**DELEGATED DECISION FOR APPLICATION FOR CERTIFICATE OF
LAWFUL DEVELOPMENT**

Reference no.: 2018/CL/91271/E

Site: 7, Hayson Close, Dewsbury, WF12 7LY

Description: Certificate of lawfulness for proposed erection of
dormer extension and alterations from hip to gable roof

SIDE

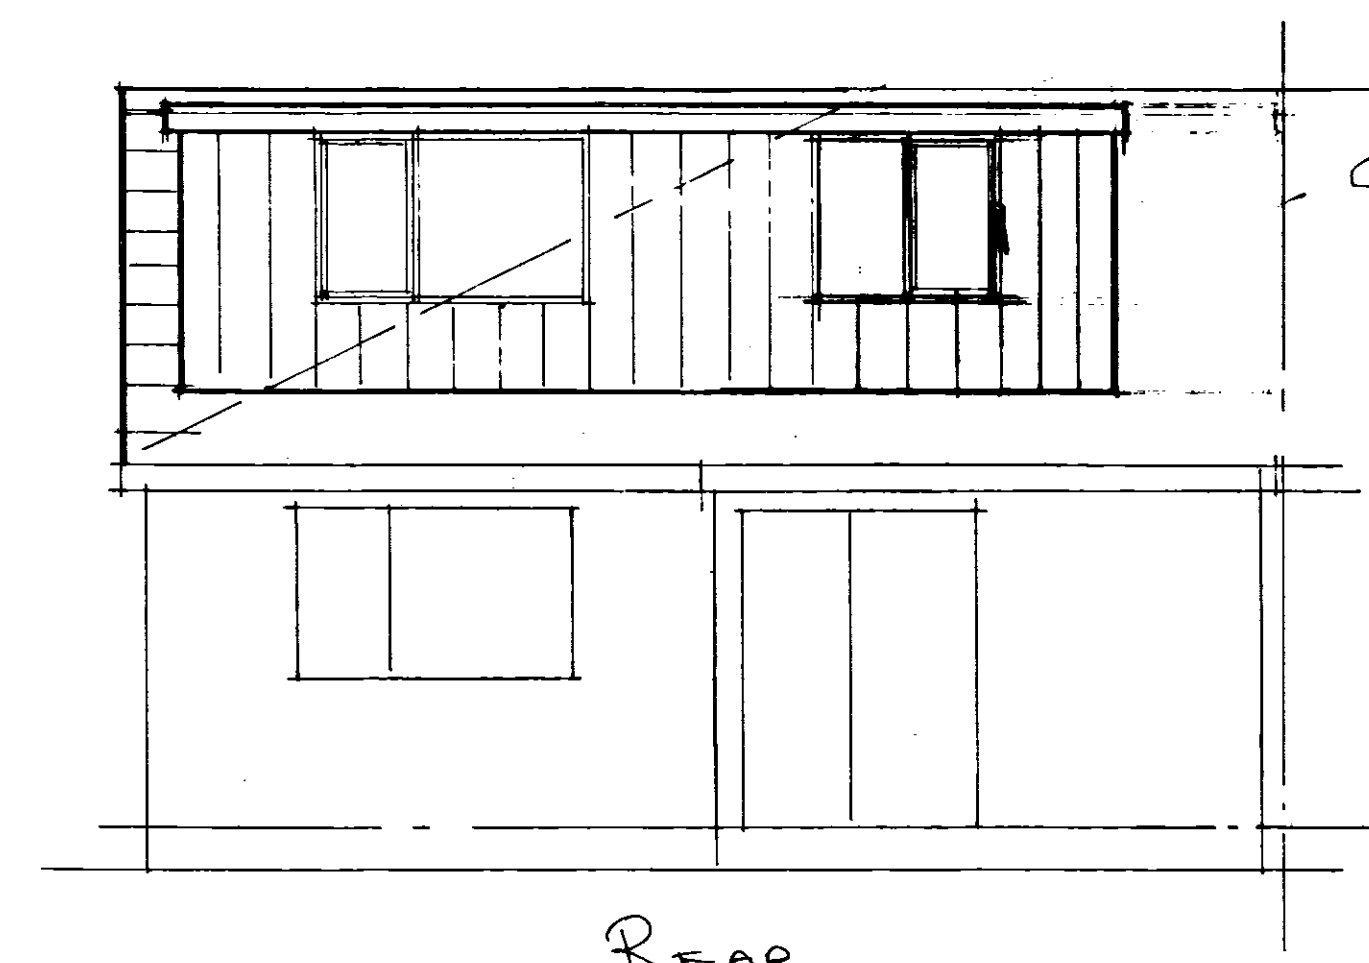
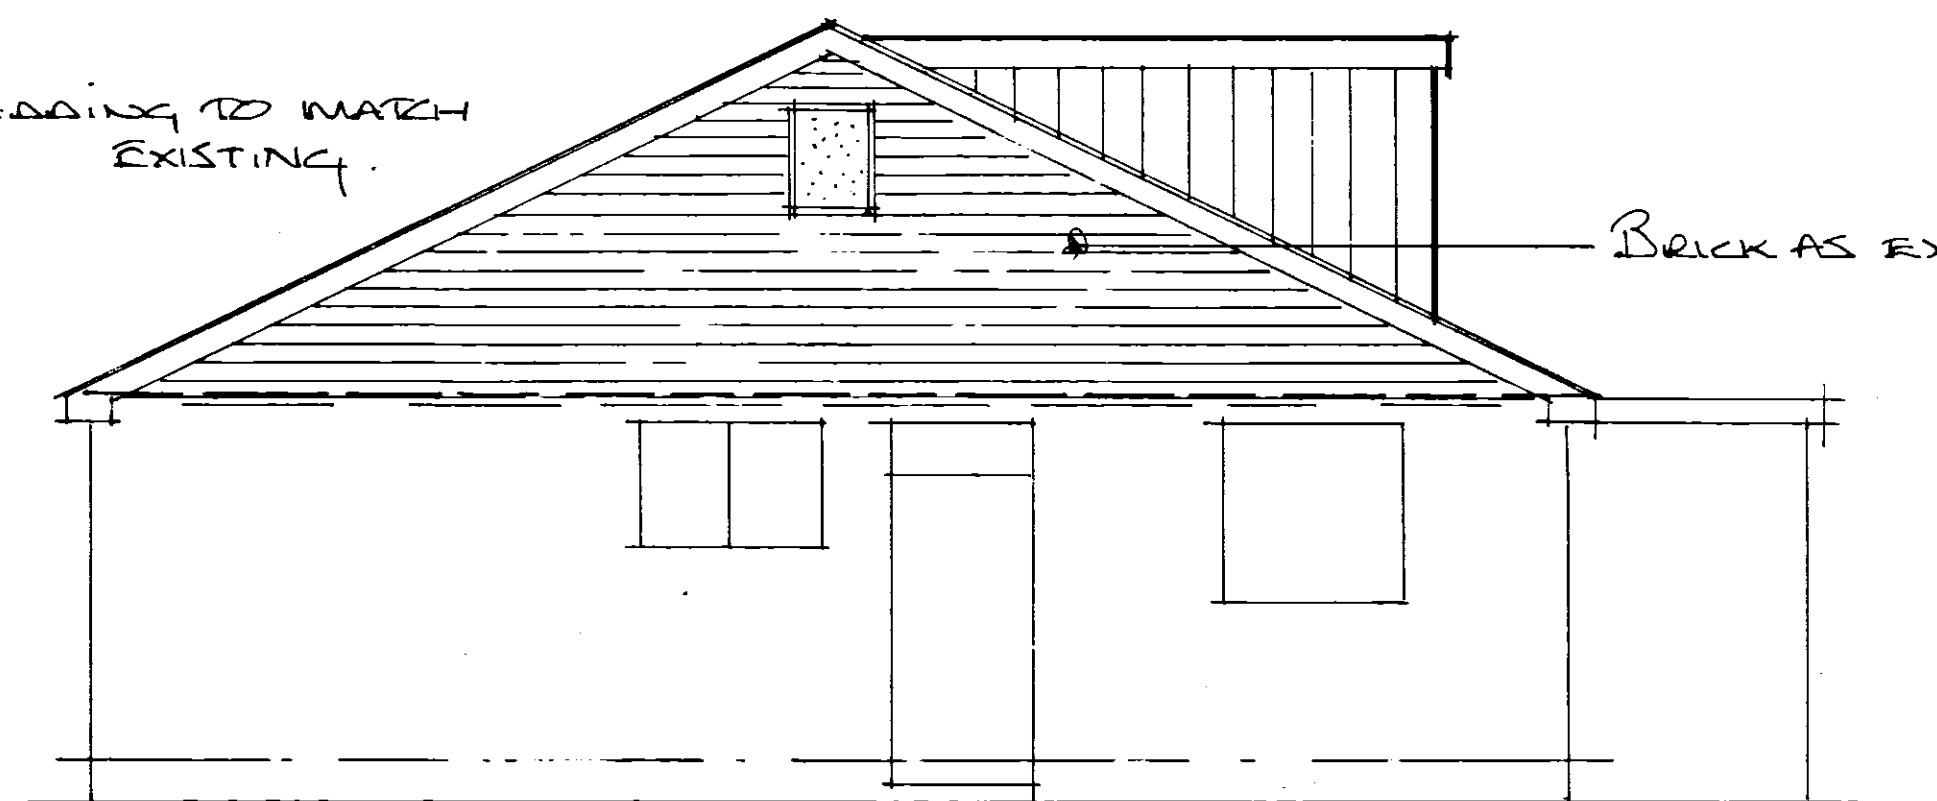
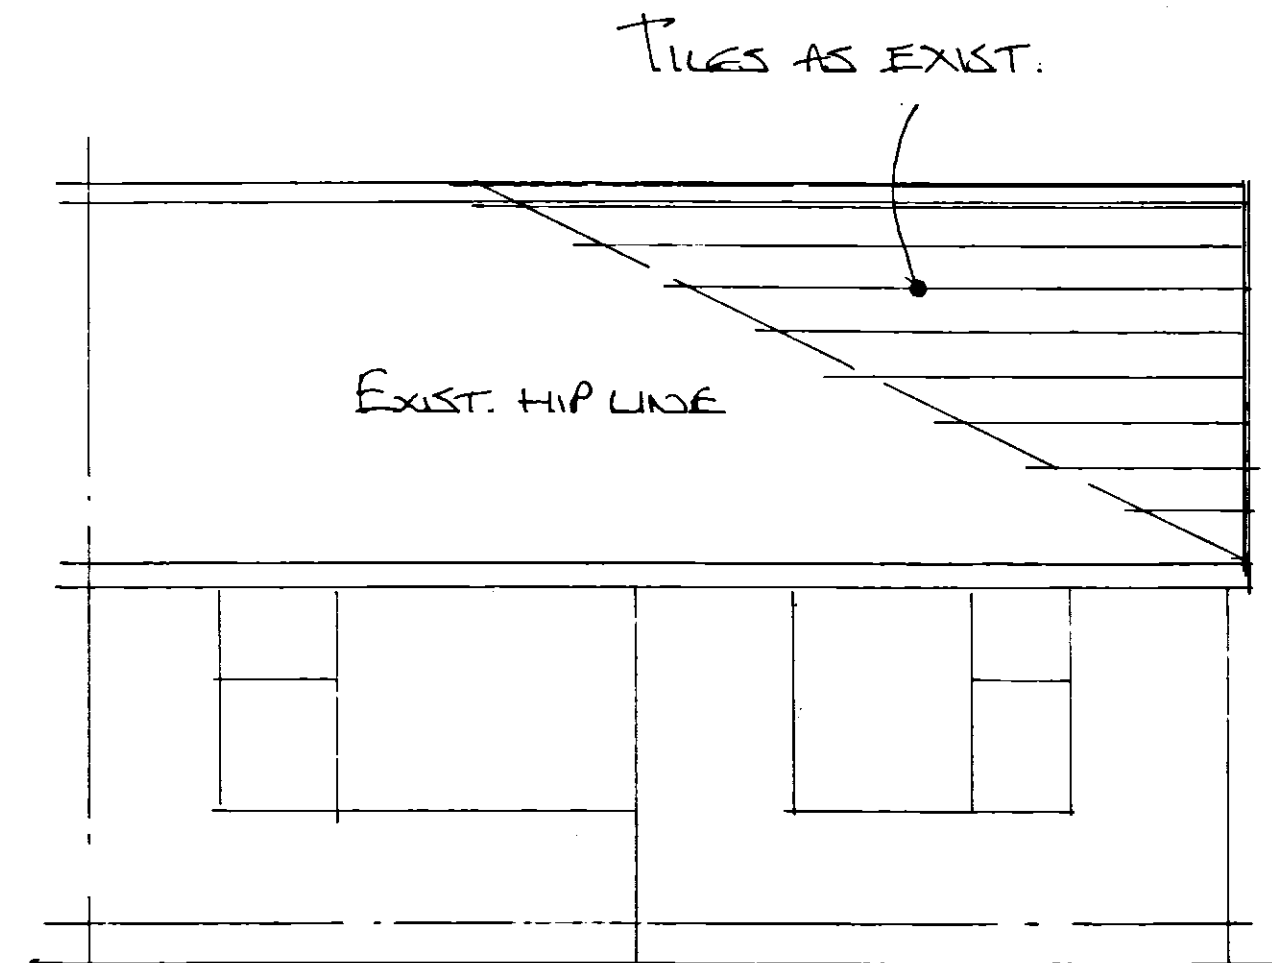
Comment: The window in the side elevation of the hip to gable extension is shown to be obscure glazed. A note shall be added to the decision notice to state that this window shall be non-opening window or at least 1.7 above the first floor level.

NOTE: Notwithstanding the submitted details on the approved plans and drawings in the plans and specification schedule below, condition B.2 of the Order states:-

(c) Any window inserted on a wall or roof slope forming a side elevation of the dwellinghouse must be—

(i) Obscure-glazed, and

(ii) Non-opening unless the parts of the window which can be opened are more than 1.7 metres above the floor of the room in which the window is installed.

Drawing Title  
PROPOSED EXTENSIONS

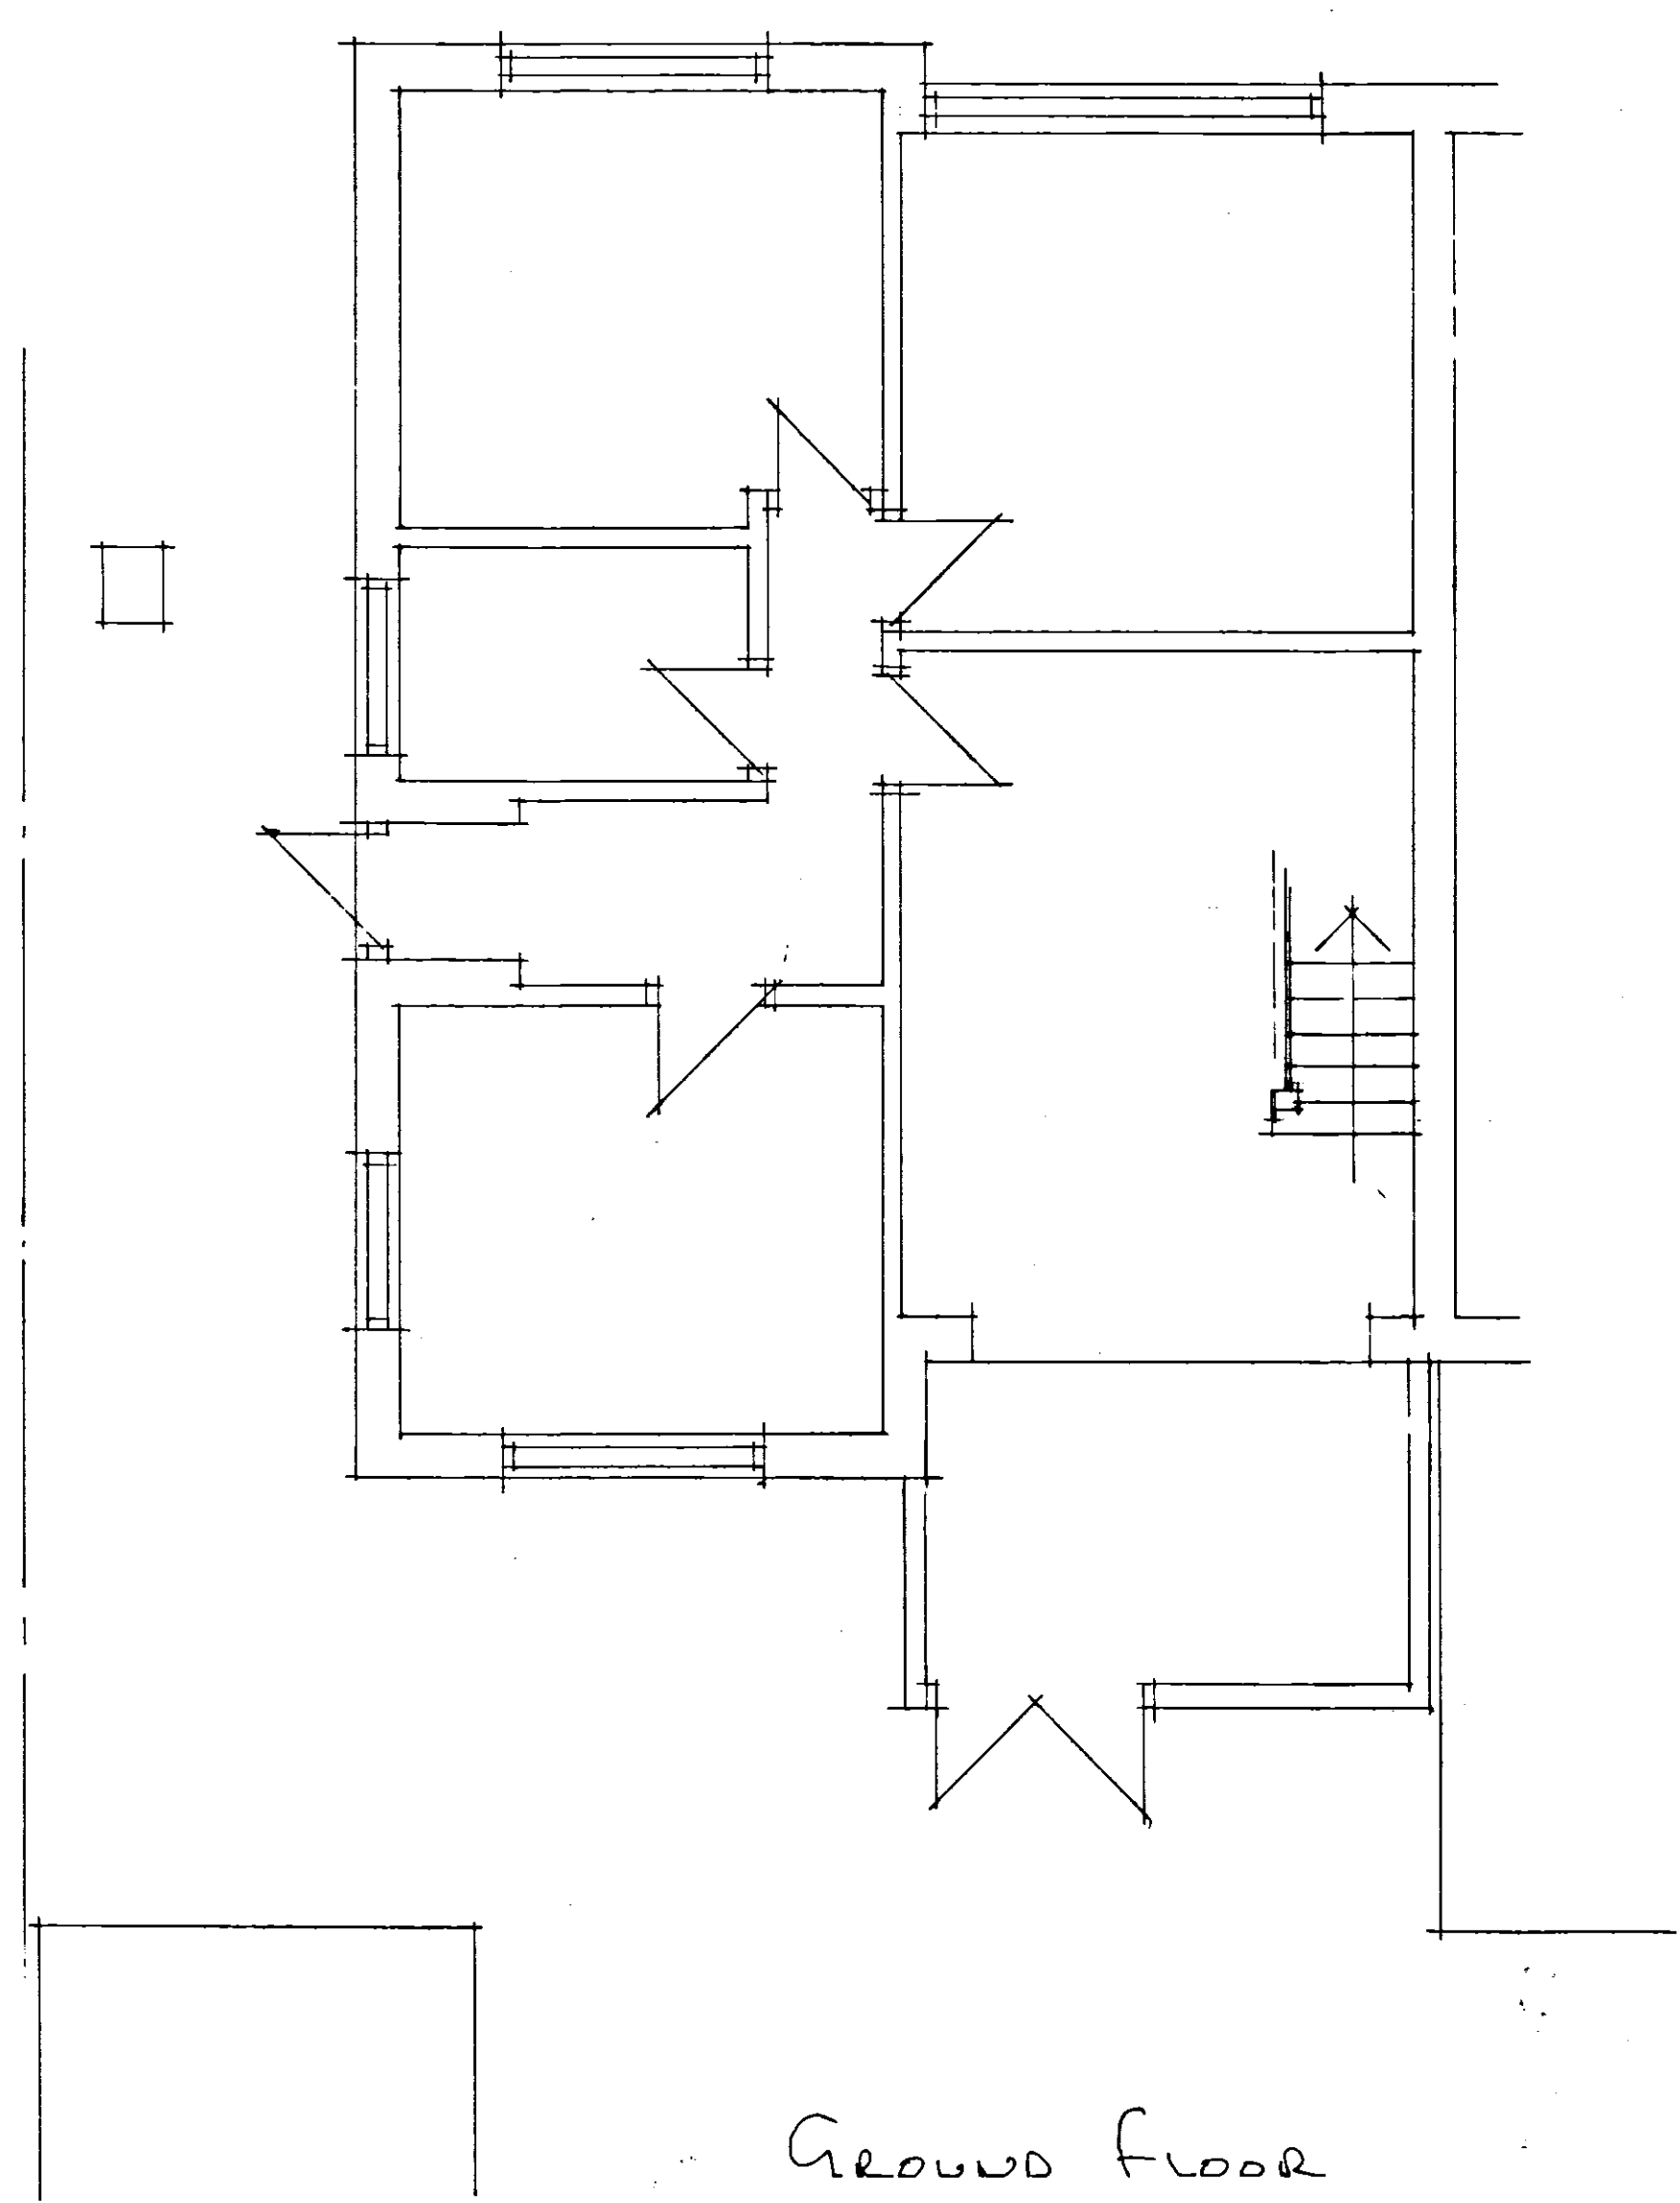
Comment: The proposal would not result in any part of the dwelling house exceeding the height of the highest part of the existing roof.

Comment: The cubic content of the resulting roof space would be 49.7m³, which equals to the sum of the roof space of the proposed hip to gable extension (20.8m³) and the roof space of the proposed flat roof rear dormer (28.9 m³).

Comment: the application form states that the building materials would match those of the existing property, though it is noted that the dormer would be constructed in cladding and flat roof membrane.

Comment: the eaves of the original roof are shown to remain the same as existing and the lowest point of the dormer would not be less than 0.2 metres from the eaves.
